Briefing Note

Our ref 64194/06/MS/OW
Date 4 June 2025
To Planning Inspectorate
From Oxford Aviation Services Limited

Subject **Deadline D1 – Further Written Statement**

- 1.1 This Statement has been prepared on behalf of Oxford Aviation Services Limited (“OASL”), the operators of London Oxford Airport (“the Airport”), in response to the Rule 8 letter received concerning the application by Photovolt Development Partners (“PVDP”) for an Order Granting Development Consent for the Botley West Solar Farm project.

\* Proposed Landscape areas are indicative  
 \*\* Areas of grassland beneath /not beneath solar arrays are managed through conservation grazing, and to deliver BNG

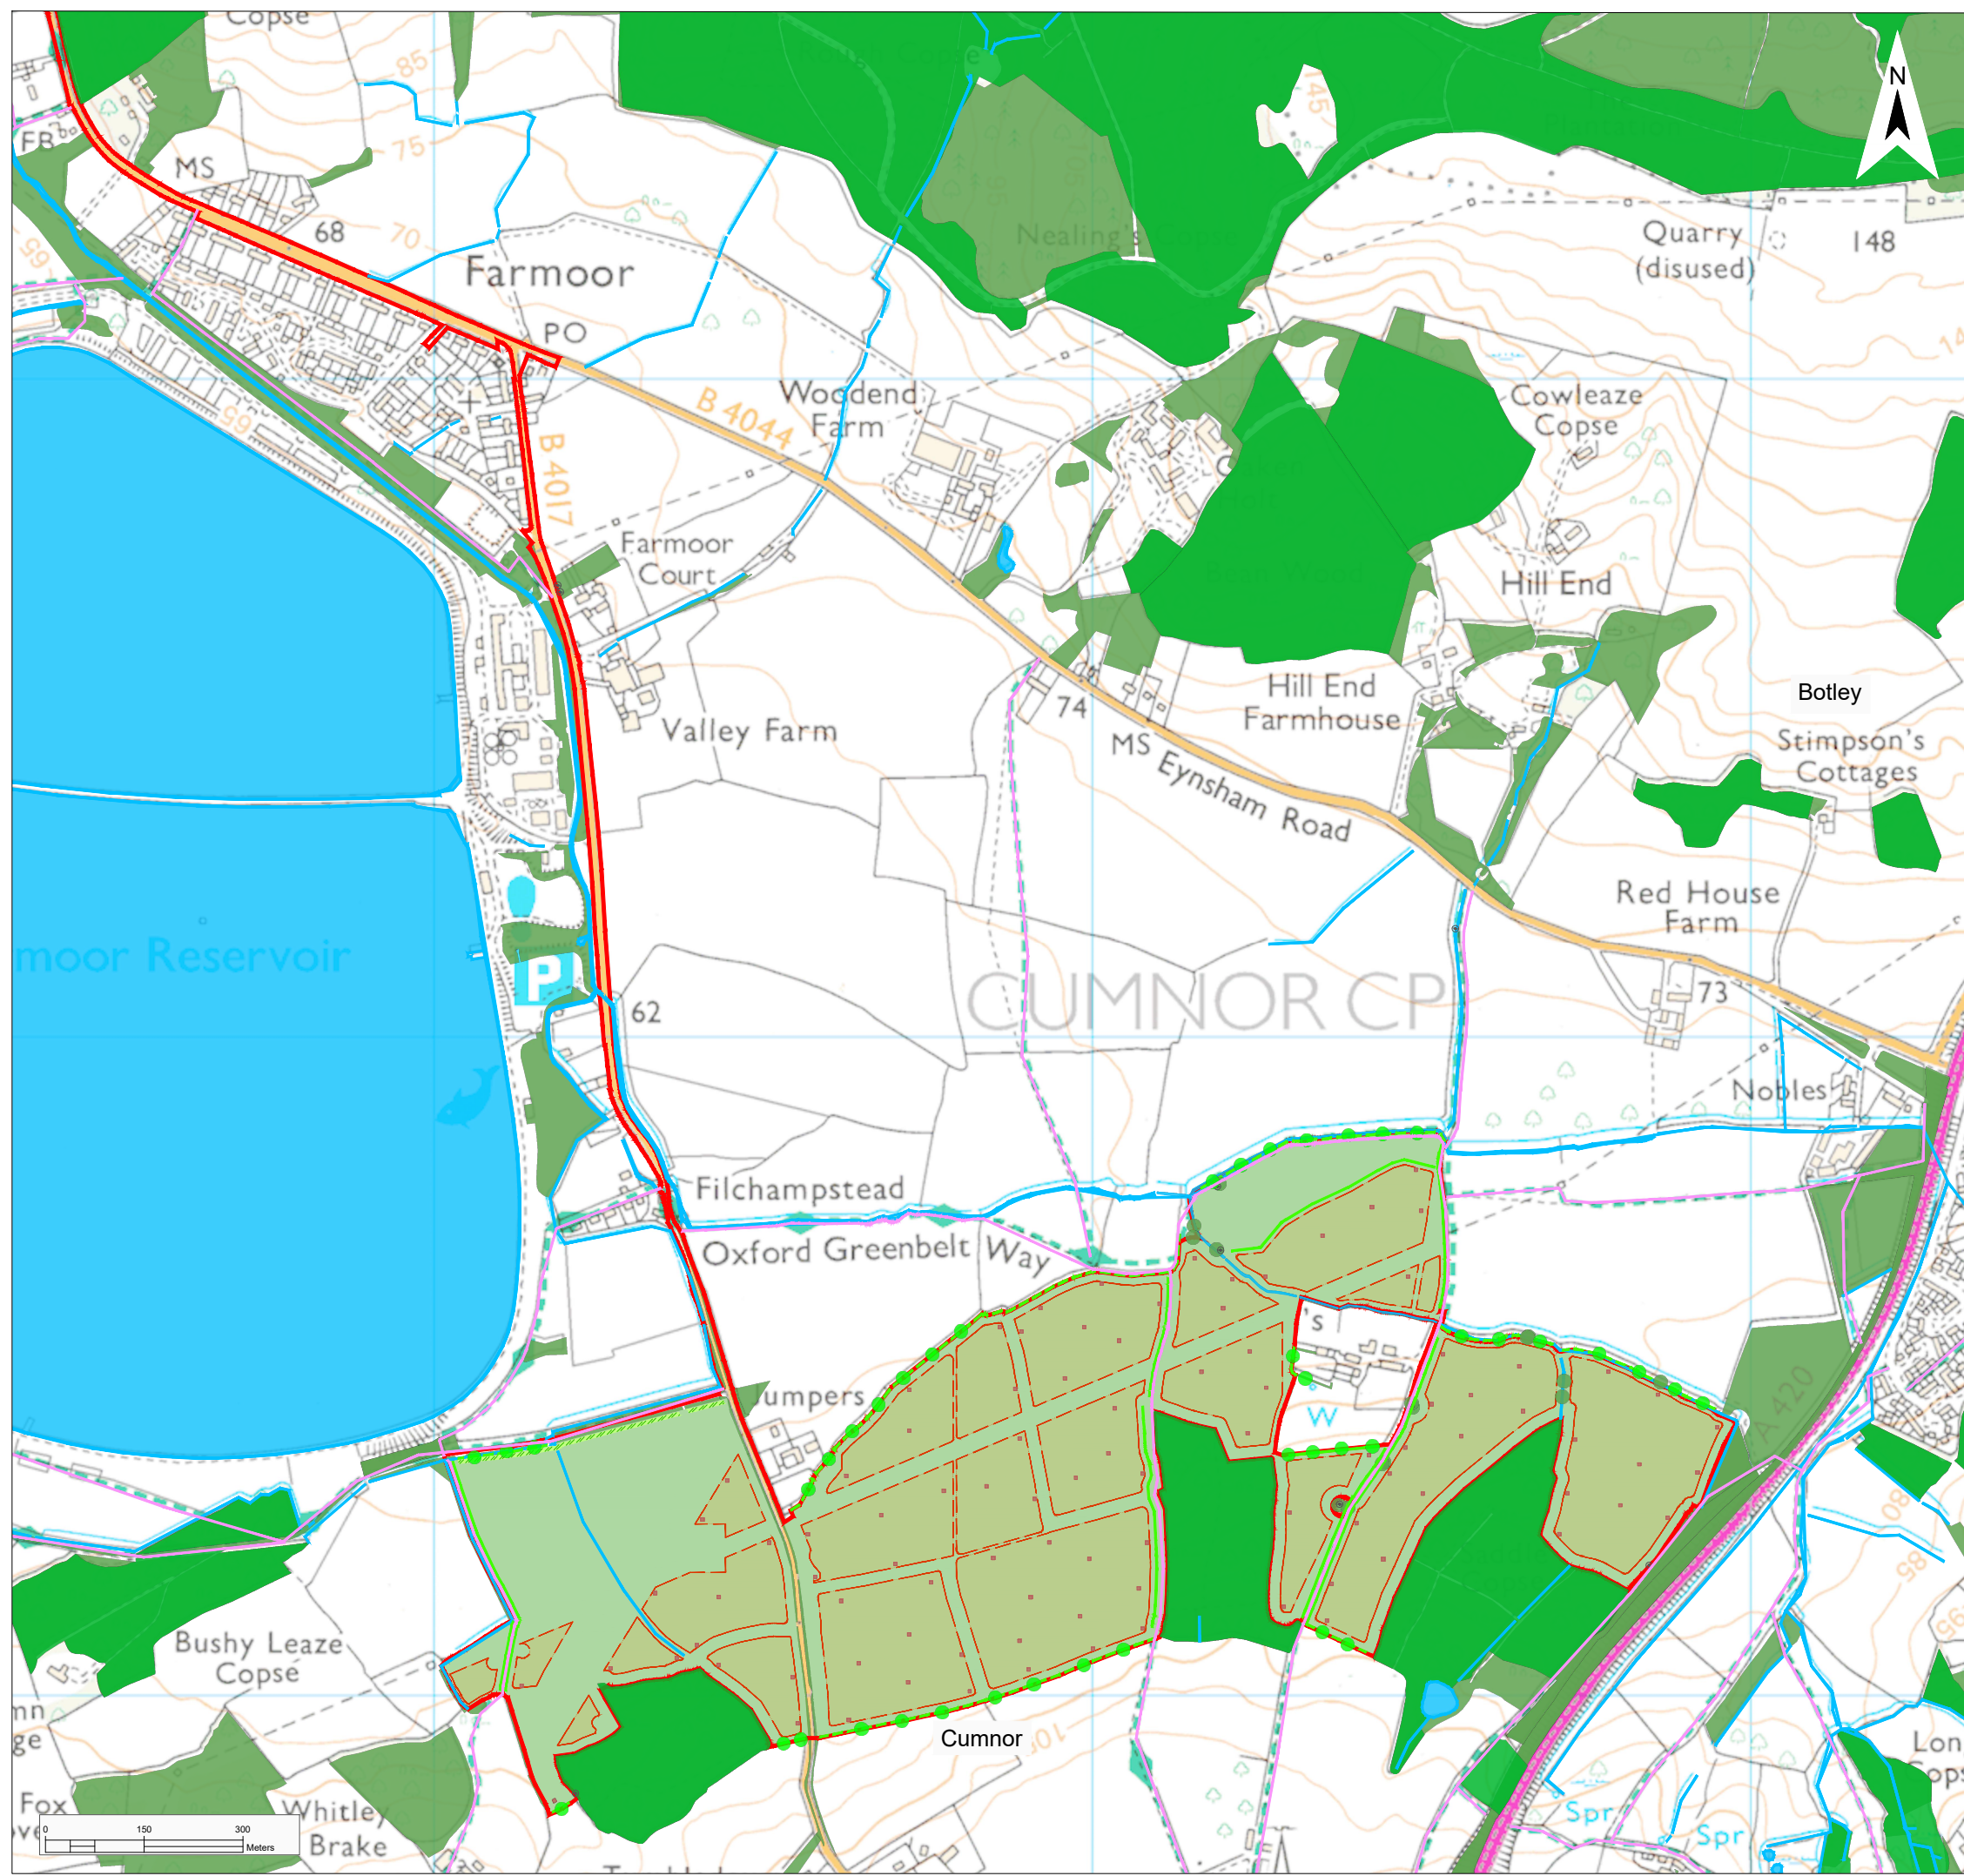
- 2.9 PVDP acknowledged that the submission documents had not considered the impact(s) of changing ecological activity around the Airport as a result of the development. It has agreed to review the proposals with a view to reducing zones of Green Infrastructure in areas around the Airport that might attract birds. They also agreed to consider other mitigations that could be introduced to assist the Airport in managing any increase in animal activity at the Airport as a result of the development.
- 2.10 PVDP agreed to present revised proposals to the Airport for review and agreement prior to submitting a proposed Change Order to the Inspectors.
